14th June 2021

Town & Country Planning (Control of Advertisement) (England) Regulations 2007 (as amended)

Application No: AB/36/21/A
Site Address: 11 High Street Arundel BN18 9AD
Description of works: Installation of a free standing sign. This application affects the setting of a Listed Building & affects the character & appearance of the Arundel Conservation Area.

Block Plan: 11 High Street, Arundel

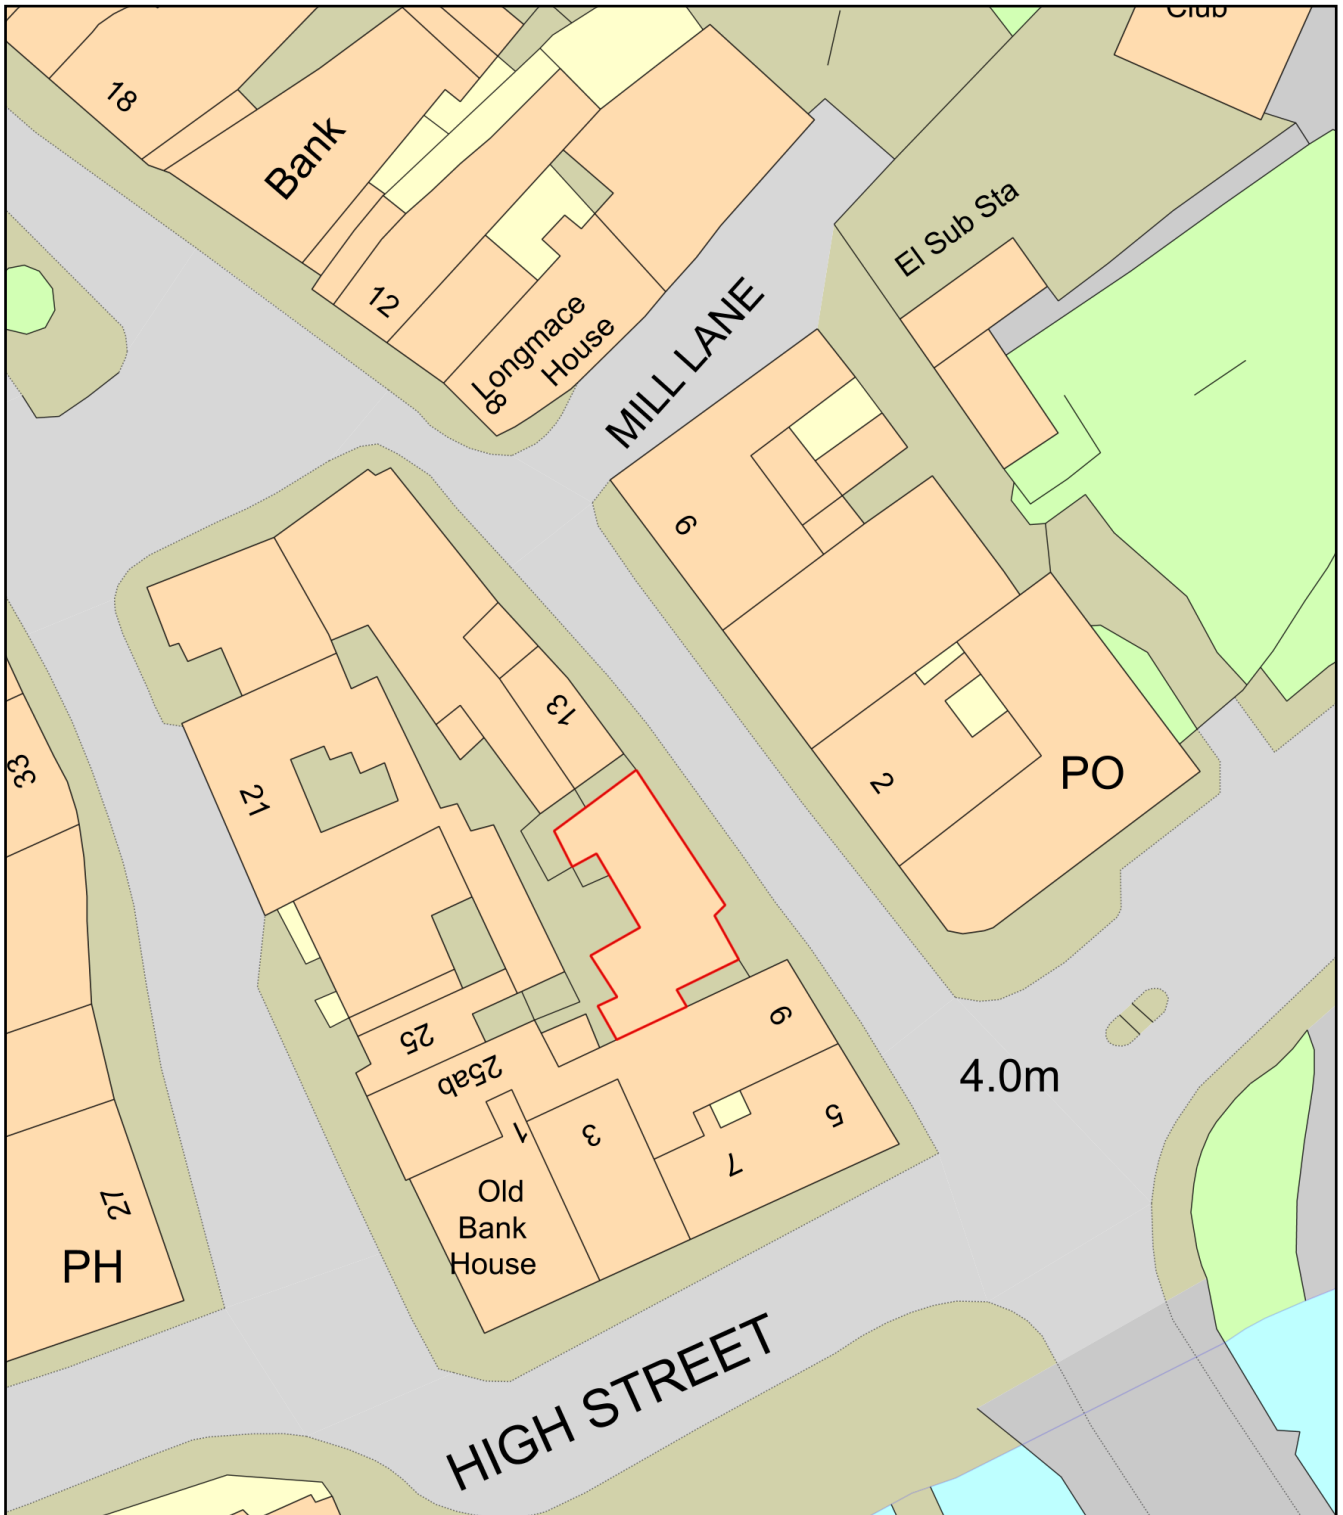
There appears to be no information on the submitted plans to indicate the proposed siting of the sign. In any event 'A' boards are unattractive and give rise to a cluttered appearance of premises and street scenes. It is questionable whether the board is really necessary on this particular property. In Arundel town centre there seems to have been a plethora of free standing boards and unnecessary signage which is detracting from the character and appearance of the conservation area, The grant of Advertisement Consent for the sign will only set a precedent for other similar proposals in the town centre and will make it difficult for the Council to undertake any future initiative to clean up and rationalise signage. It is appreciated that shops and cafes are facing difficult economic times but unnecessary, cluttered and unattractive signage can be both confusing for customers and detract from the visual and historic environment which draws visitors to towns like Arundel in the first place.
